DRB CASE ACTION LOG

DRB Application No.: 03-00791 (P&F)
Project Name: Lands of Sandra Elena Garcia
Agent: Lawrence Garcia

CITY OF ALBUQUERQUE
Planning Department
Development Review Board
May, 28, 2003 Comments

RE : Lands of Sandra Elena Garcia

SITE PLAN

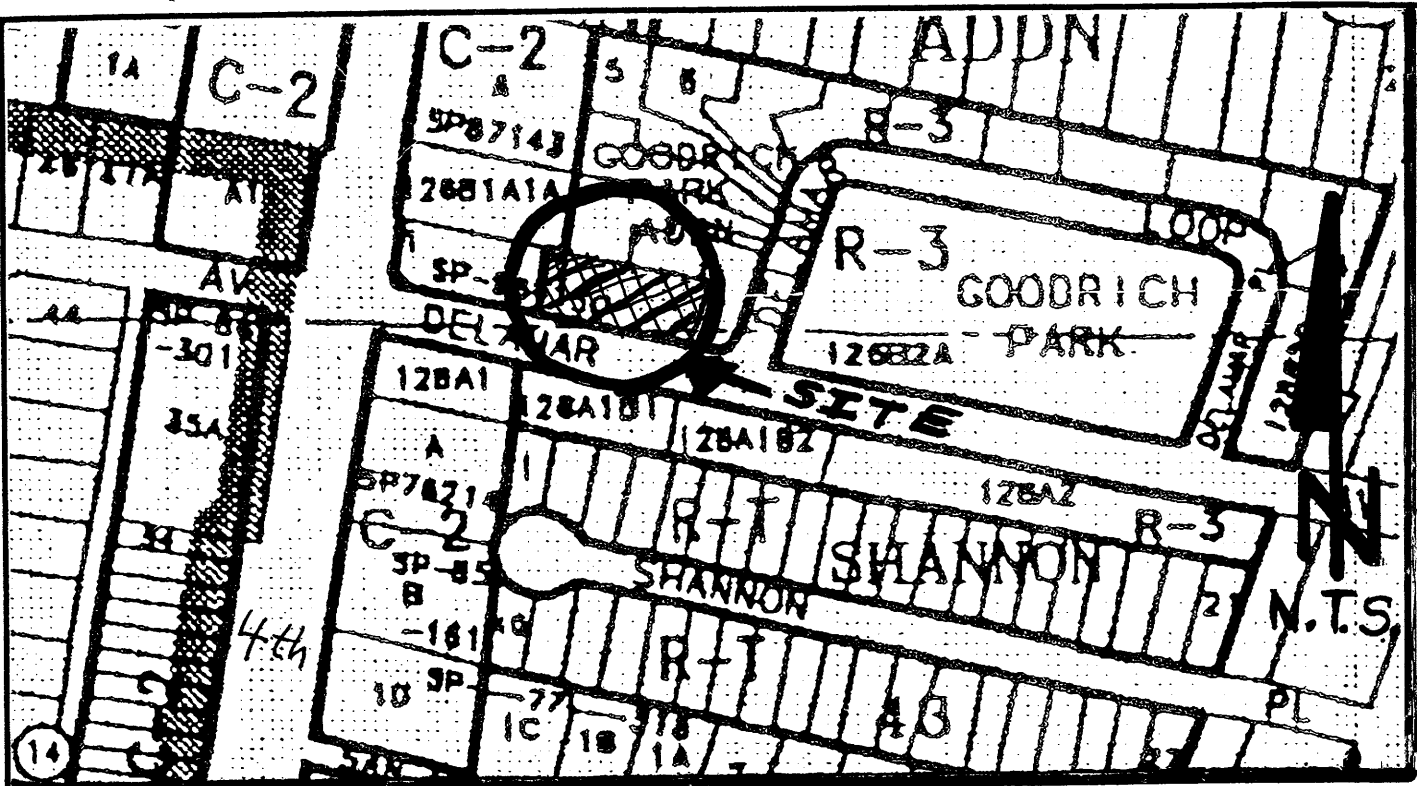
| SDUKS TO BE CONSTRUCTED PRIOR TO C.O. | | |

| No. | Comment |
|--------------------------|--|
| <input type="checkbox"/> | Is there existing curb, gutter and sidewalks on Delamar? |

PLAT OF LOTS 2A, 2B, 2C and 2D  
Lands of Sandra Elena Garcia  
Situating Within, T.11.N, R.2.E  
City of Albuquerque  
Bernalillo County, New Mexico  
MAY 2003

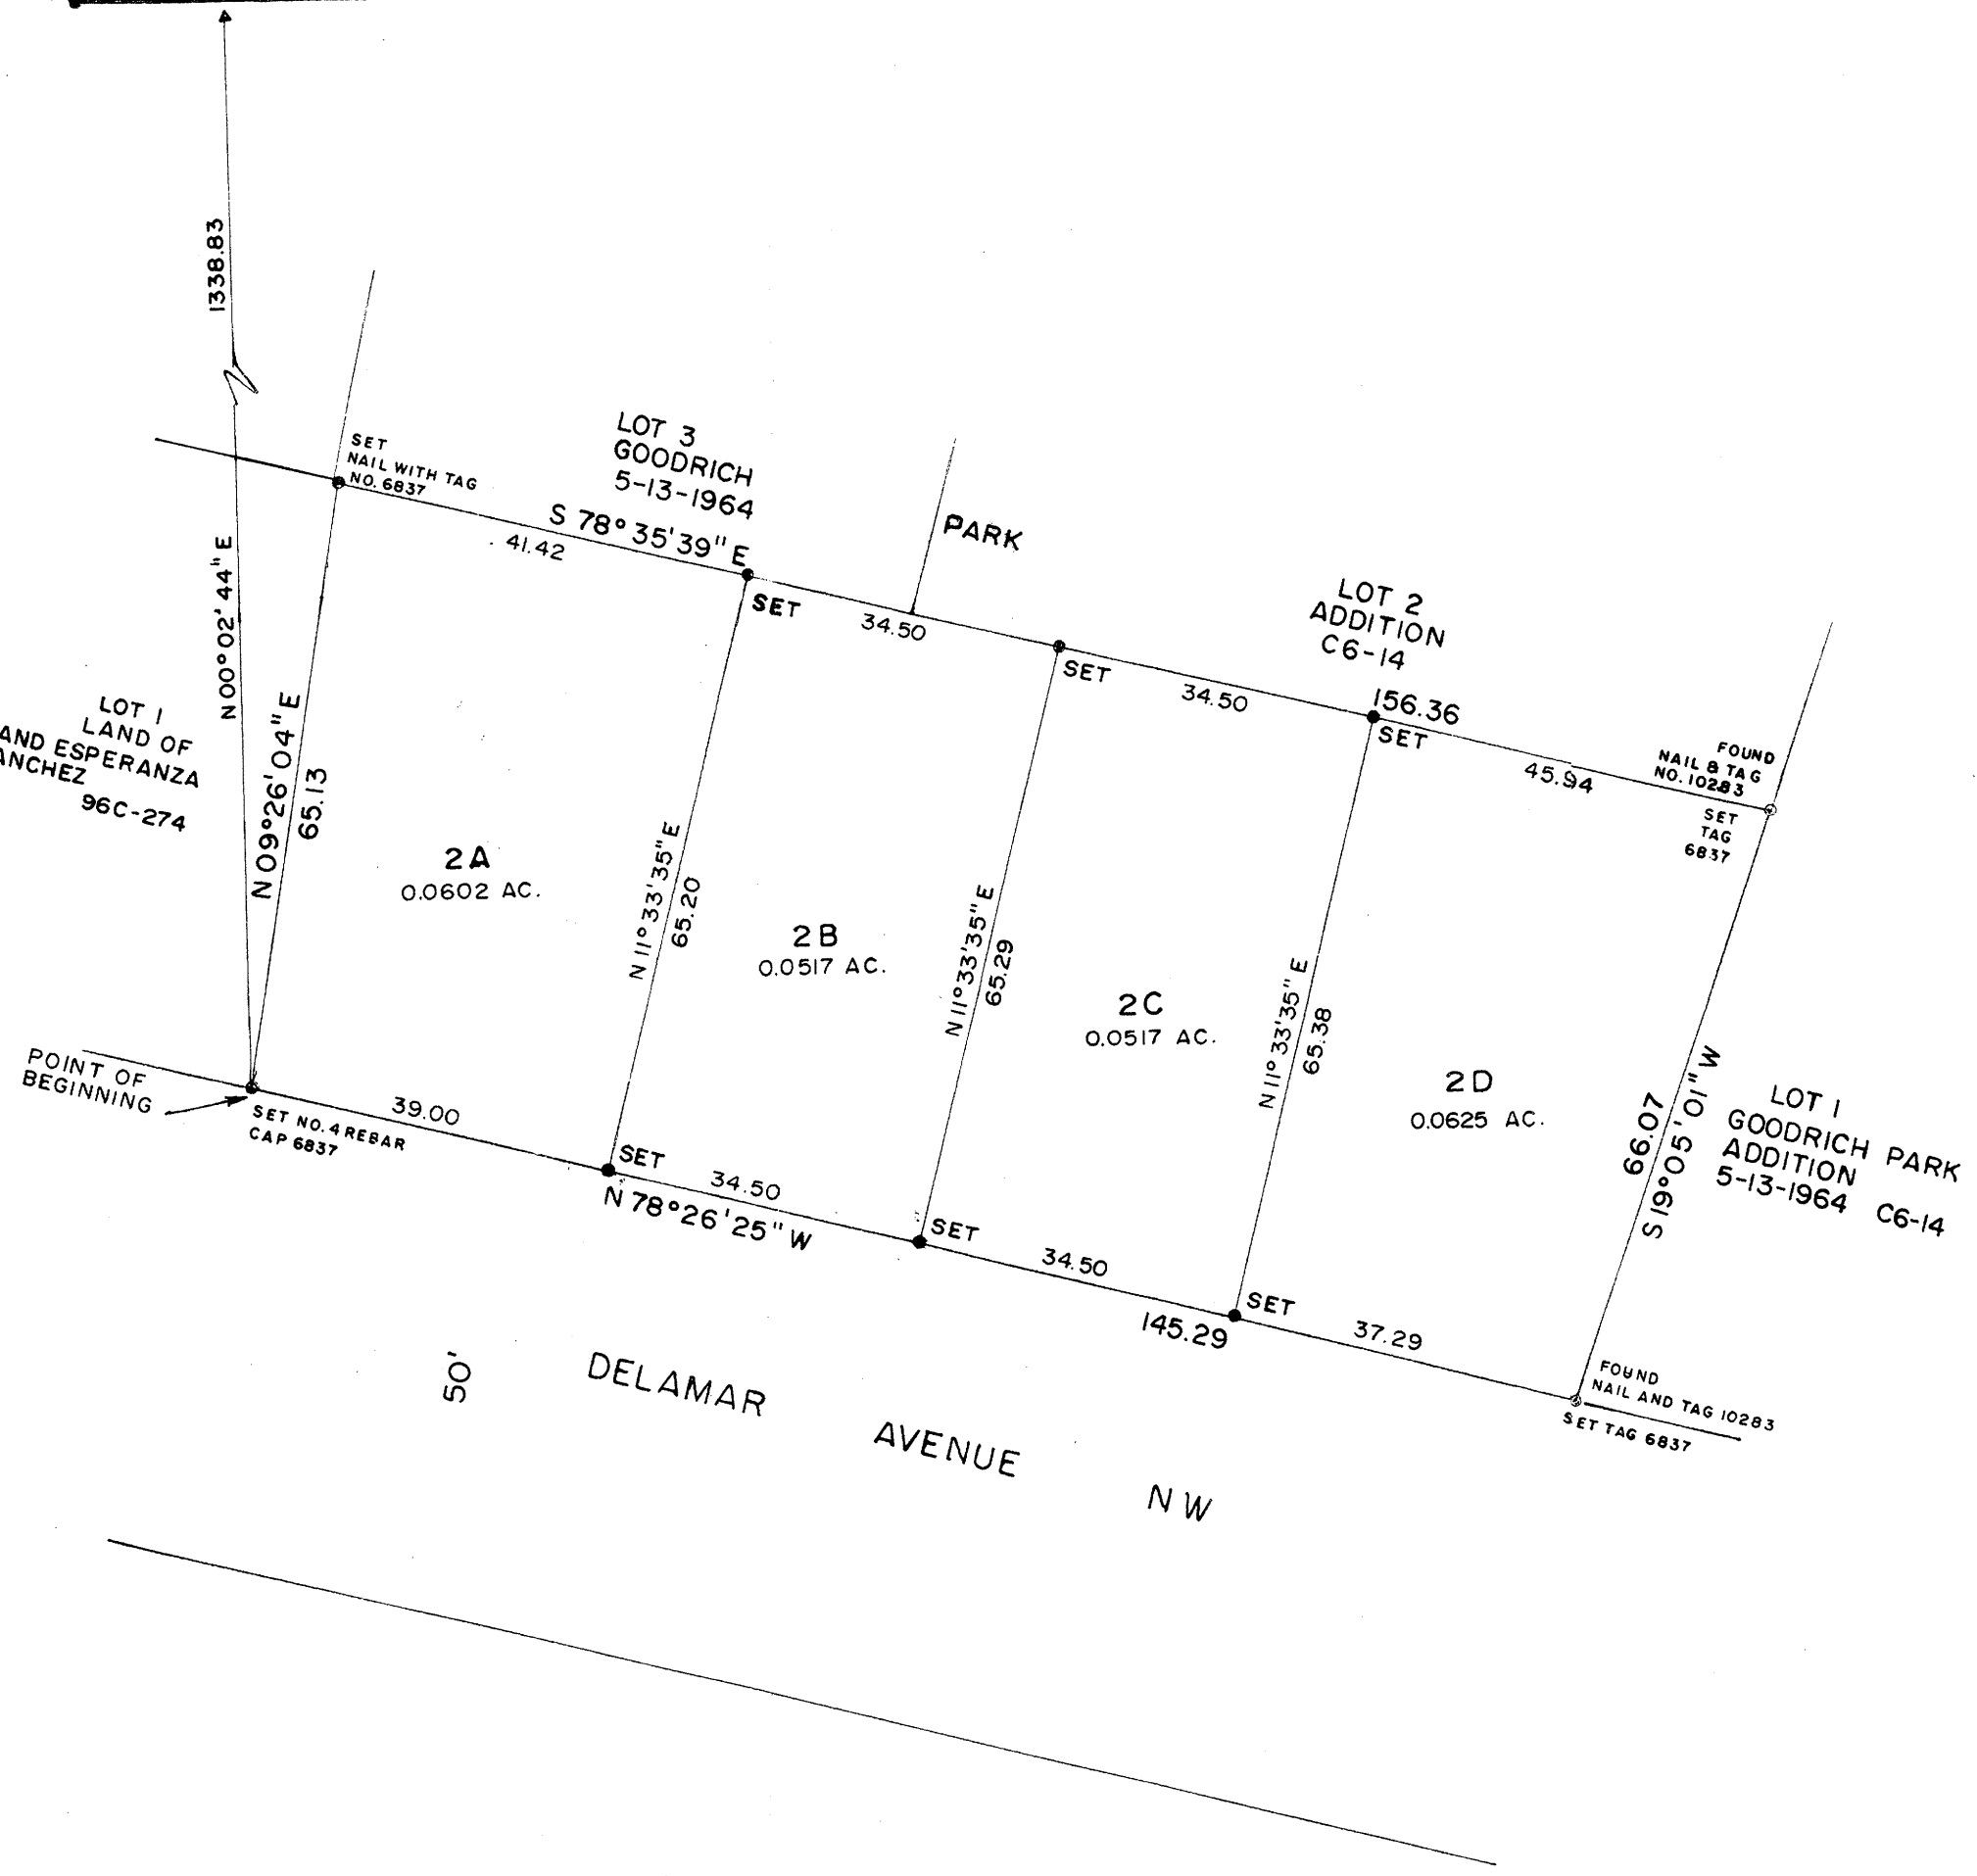
R-3 zoning requirements state that lots non conforming in width to the R-3 minimum lot width requirements are to conform to the lot size requirements of the RT zone. RT requirements are 22 feet lot width and 2200 square feet total lot size.

Lot sizes are okay as shown on the sketch plat.
